City of Albuquerque

February 2, 1996

**RE: LA AMISTAD SENIOR HOUSING (J14-D113) GRADING PLAN FOR
GRADING PERMIT APPROVAL. ENGINEER'S STAMP DATED 1-12-96.**

TITLE: LA AMISTAD SENIOR HOUSING
LANDSCAPE AND SITE IMPROVEMENTS
GRADING PLAN

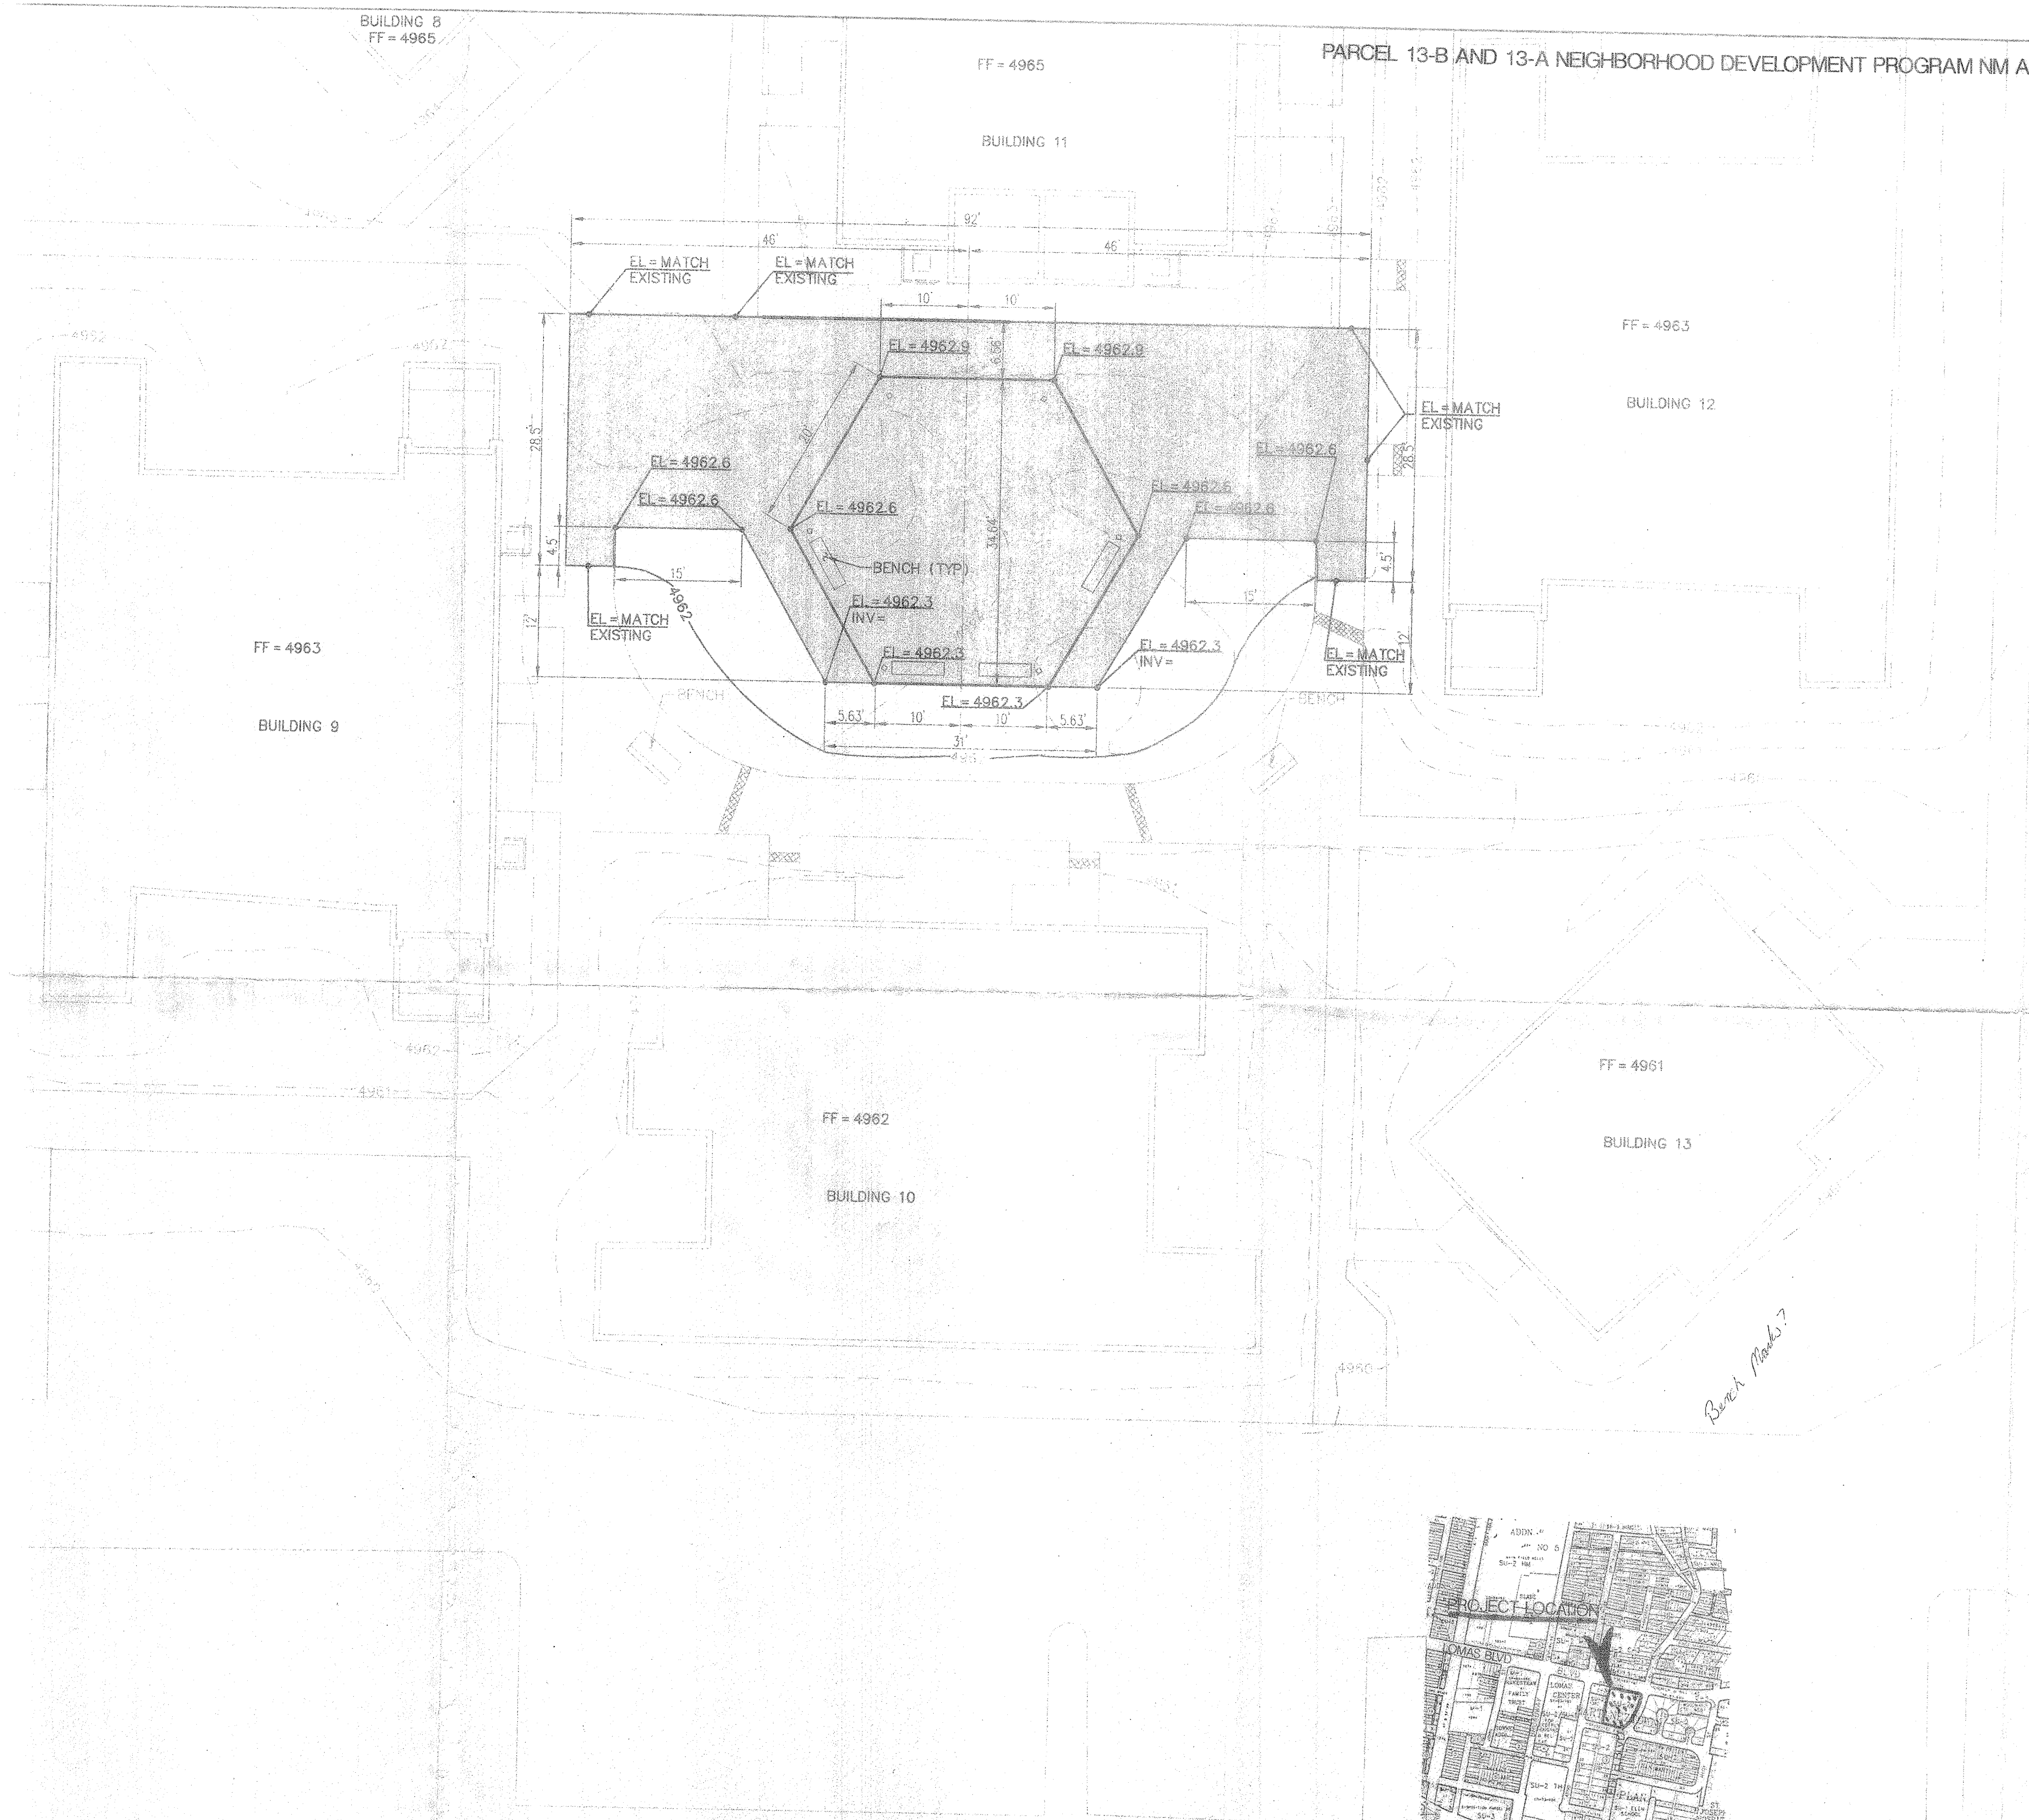
I am assuming that an existing finish floor elevation will be used as a temporary bench mark and that all finish floor elevations shown are correct. An Engineer's Certification will be required. You will have to show that the project ties into a City of Albuquerque permanent bench mark prior to final acceptance.
